Application No: A/130/21/PL

Recommendation Report for Planning Permission

LOCATION: 16 Pine Trees Close
Angmering
BN16 4LT

PROPOSAL: Demolition of existing garage, conversion of extension (approved under A/66/21/HH) to 1 No. 2 bed dwelling, provision of 4 parking spaces and cycle/refuse storage. This application is within CIL Zone 2 and is CIL liable as new dwelling.

O5 PROPOSED ELEVATIONS
SCALE 1:50 @ A1

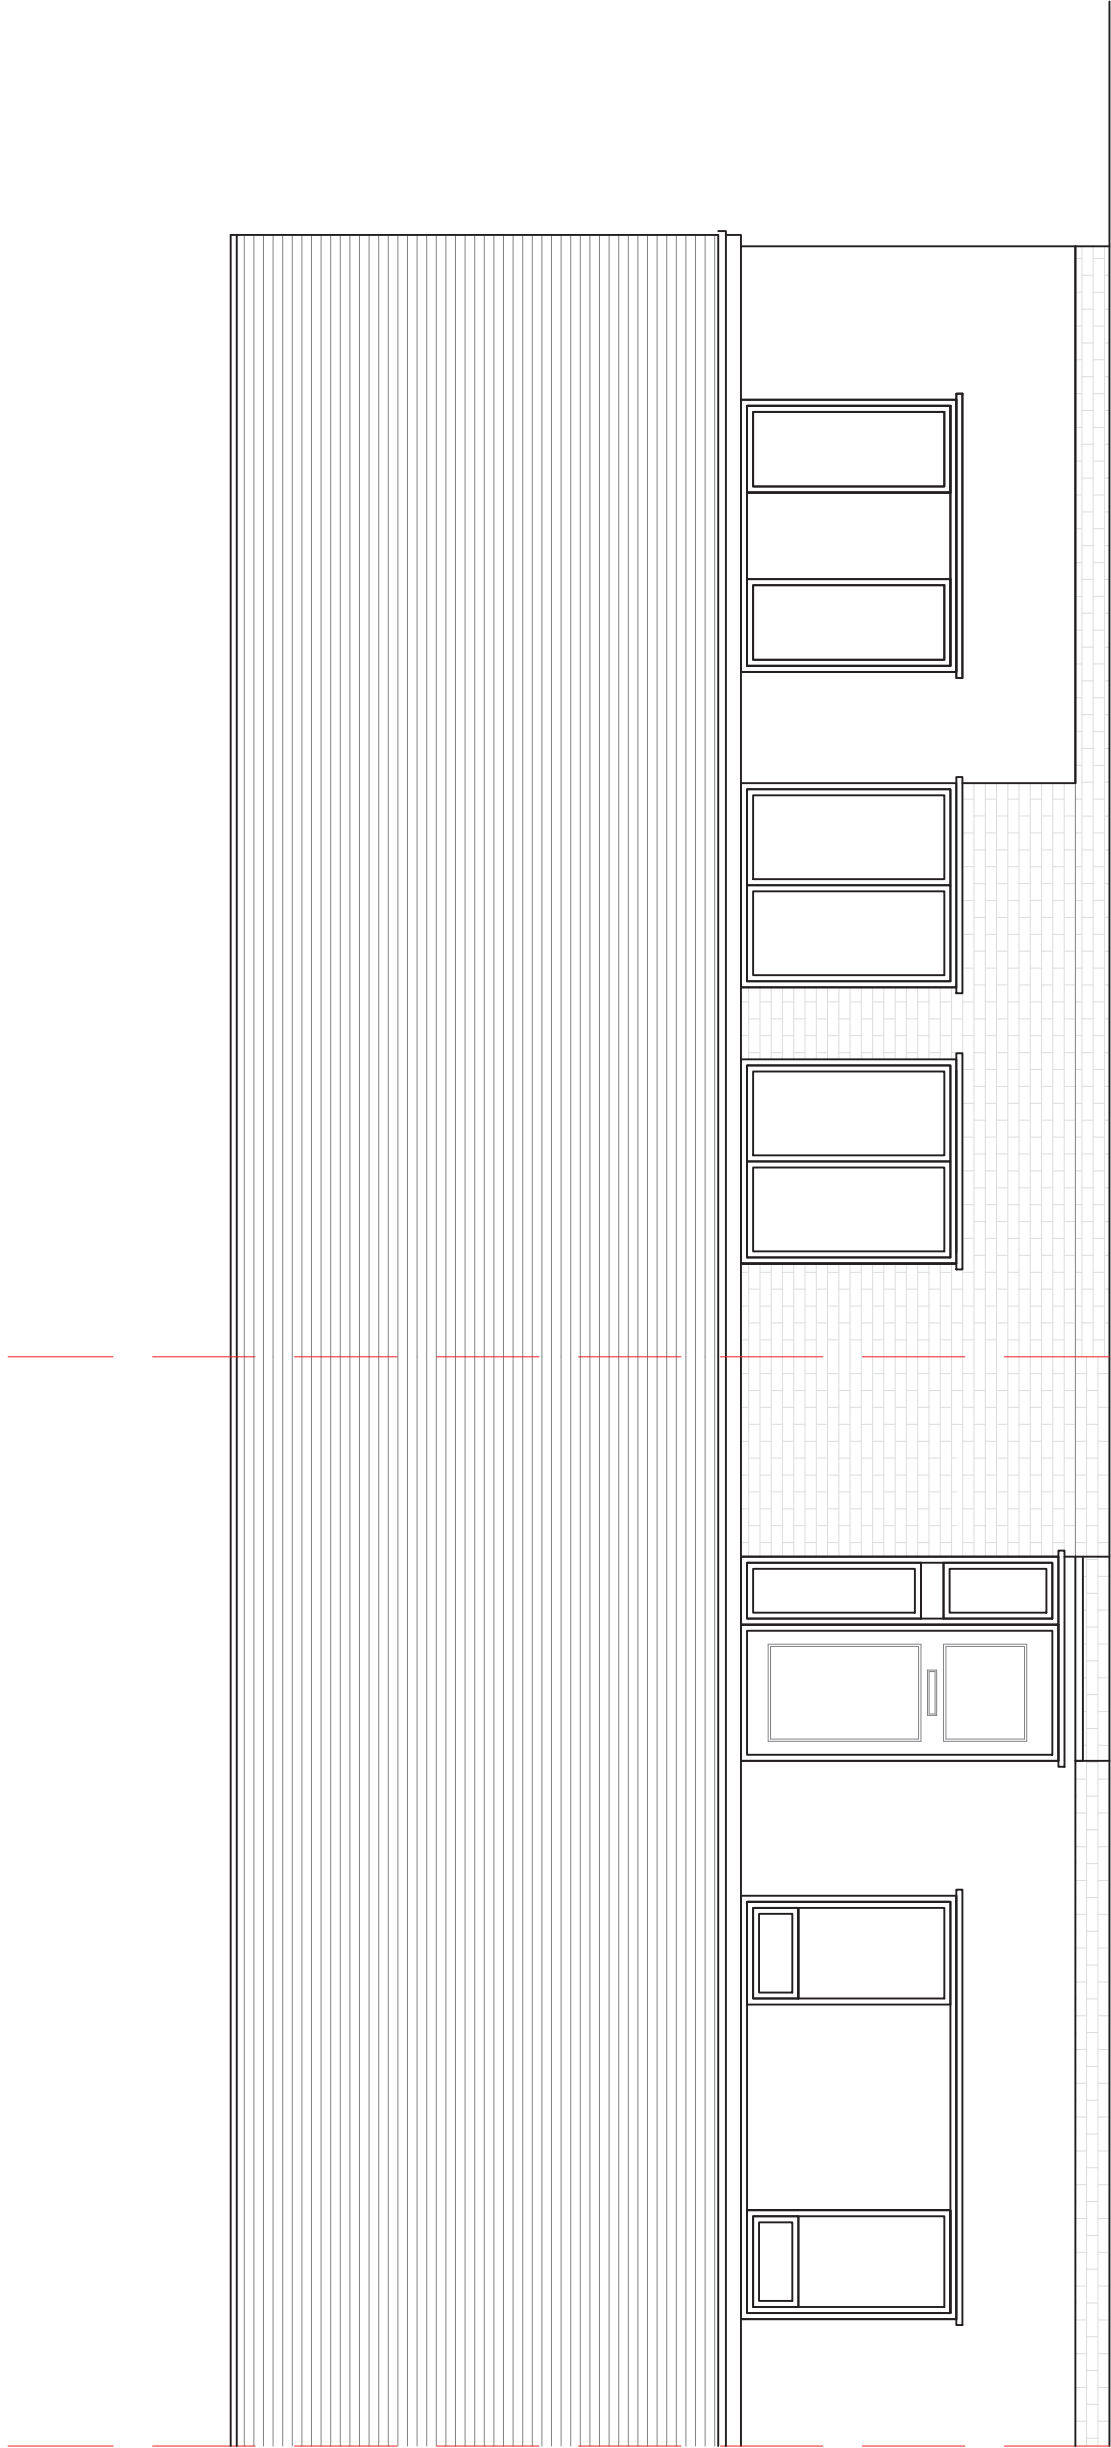
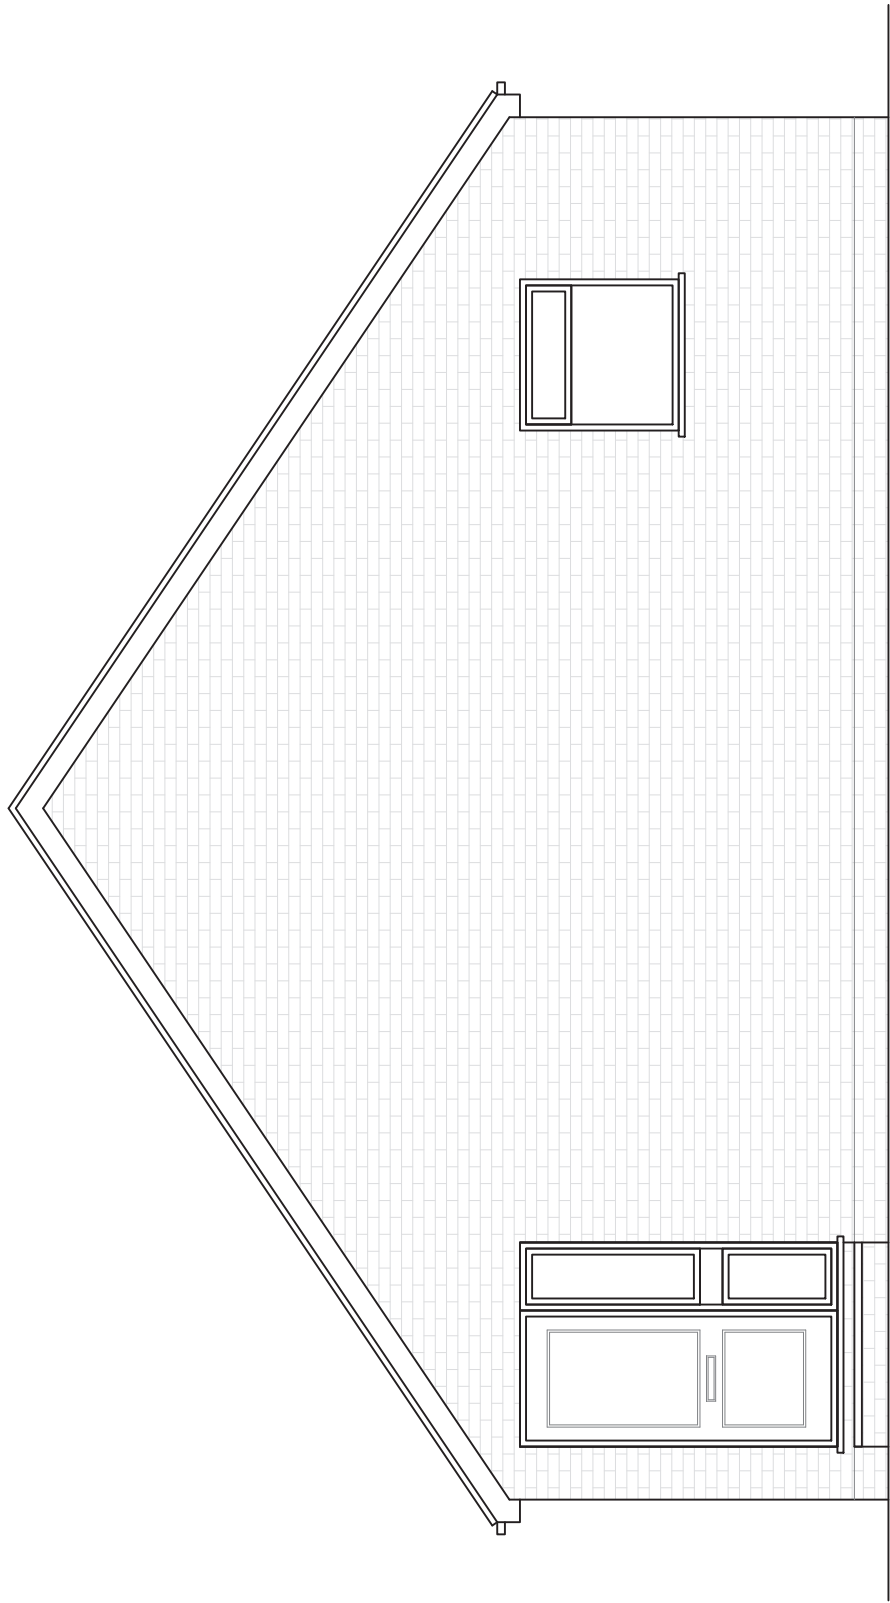
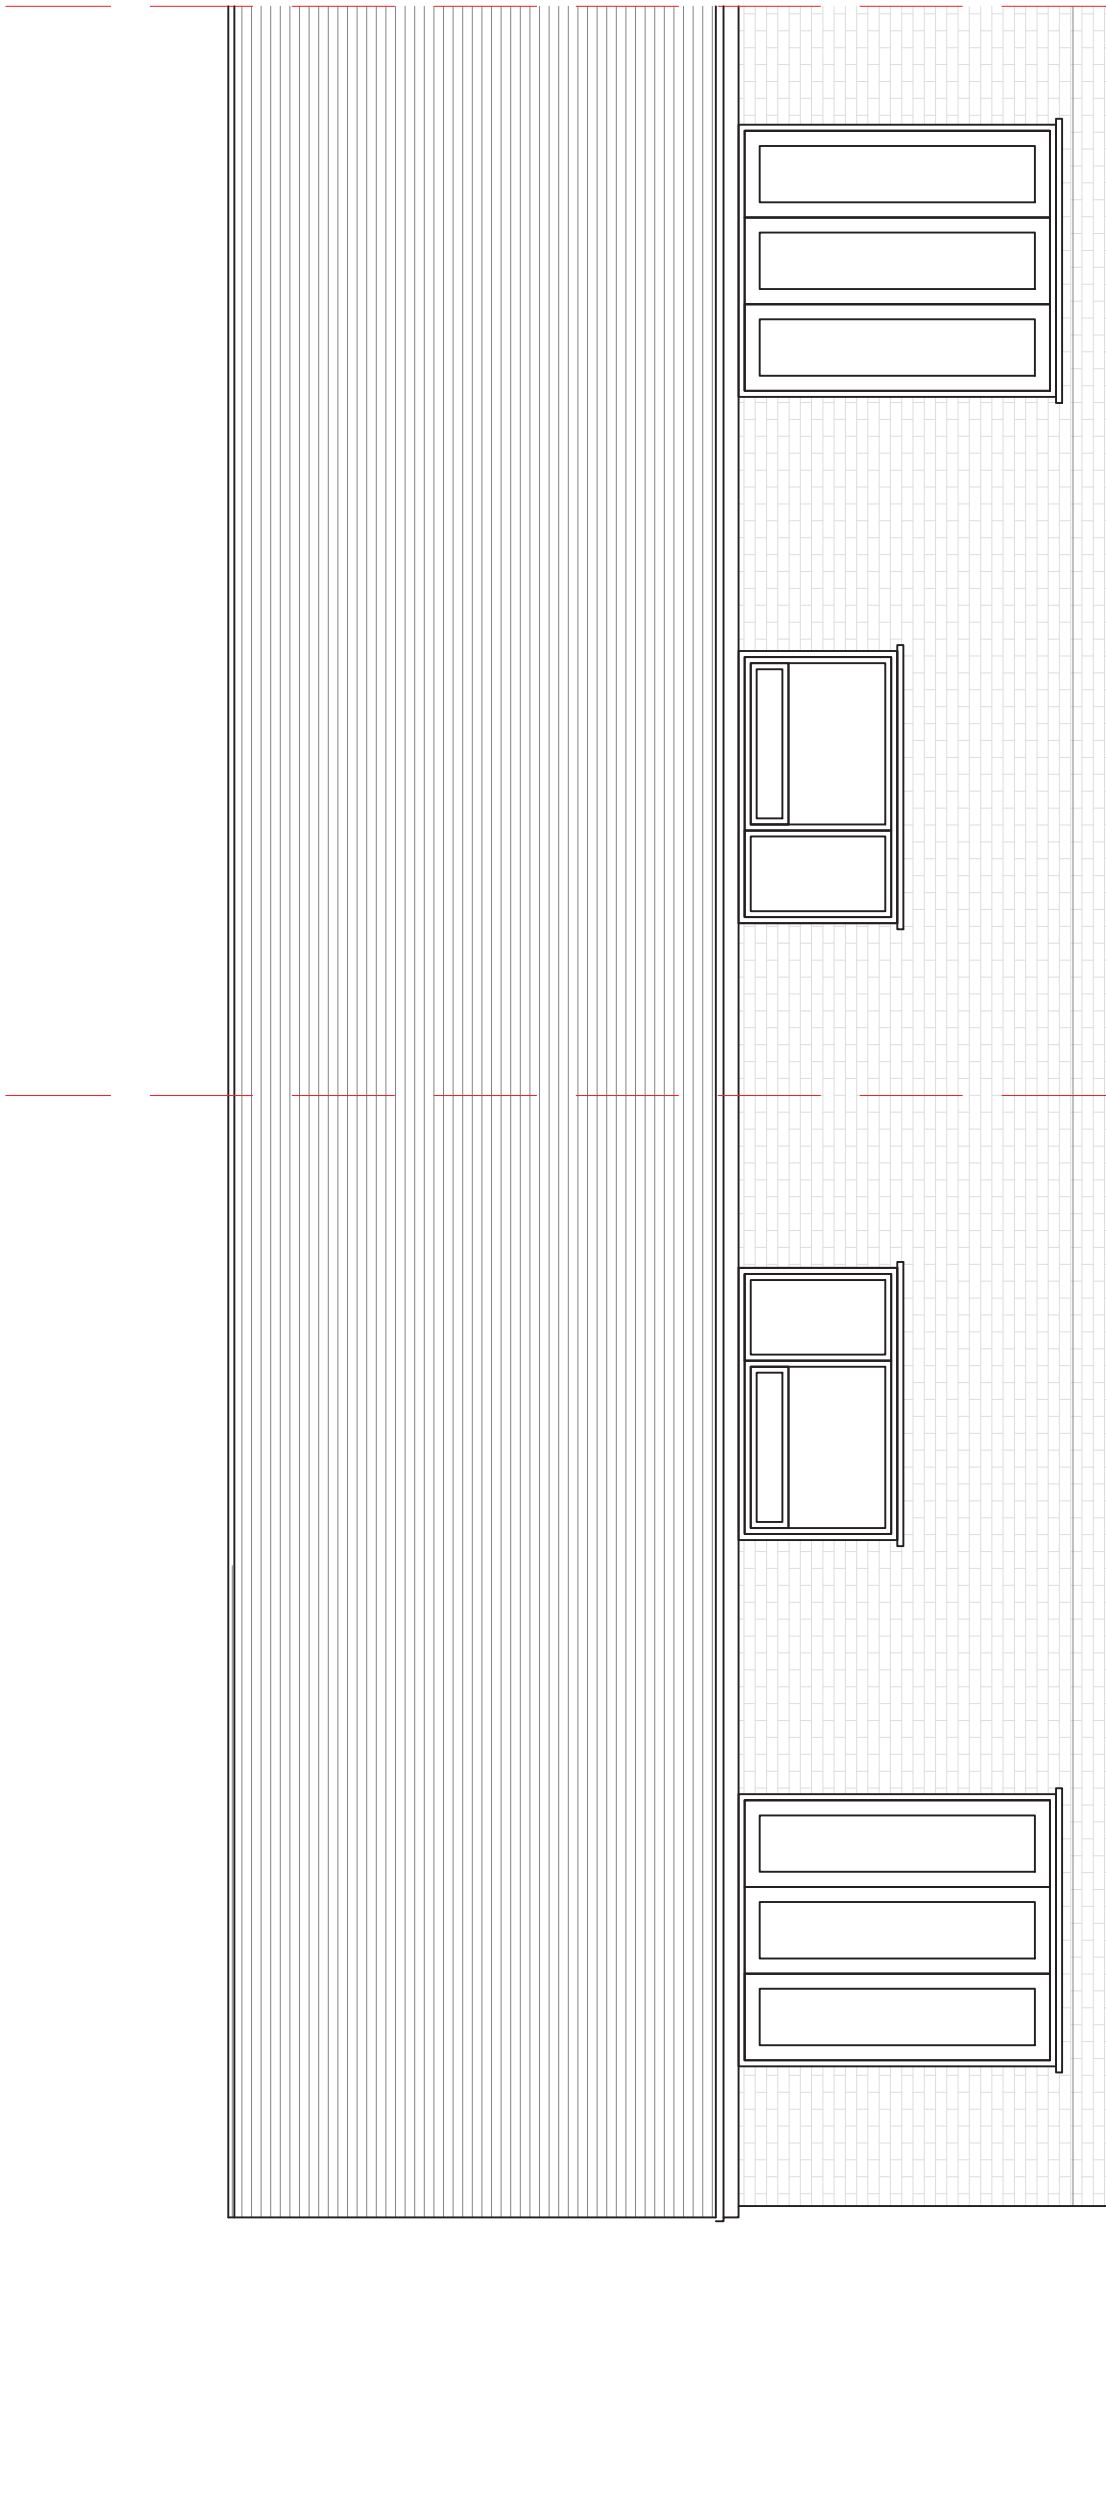
The proposed development is almost identical to A/66/21/HH, apart from the sub-division of the plot to create a new dwelling house. Externally, the single storey pitched roof side extension to 16 Pine Trees Close would mirror the previously approved scheme.

house which would consist of 2 bedrooms, a lounge, a kitchen/diner and a bathroom. The front door would be positioned to the side of the dwelling and the sub-division of the plot would not affect the appearance of the dwellings when viewed from Pine Close. The extension has been sympathetically designed, with an eaves height and ridge-line which run through to existing levels and therefore its scale and style is appropriate for its intended use. The extension would be visible from the street, however, it does not have a direct street frontage and has the effect of disappearing into the side garden of the host dwelling. Additionally, it maintains the building lines of the existing dwelling and is subservient to the existing dwelling. It is proposed to increase the size of the property by nearly 100% of the existing dwelling. Current guidance in the Local Plan and Arun Design Guide states that extensions over 50% increase of floor space would be considered disproportionate and are unlikely to be acceptable, although it is noted that this property has the benefit of a slightly larger rear/side garden, a single garage is to be demolished and as the site is located at the head of Pine Trees Close with no direct neighbours and in this instance this is not a reason to refuse the application. Given the above and the good visual integration through appropriate material and style choice the single storey pitched roof extension is acceptable.
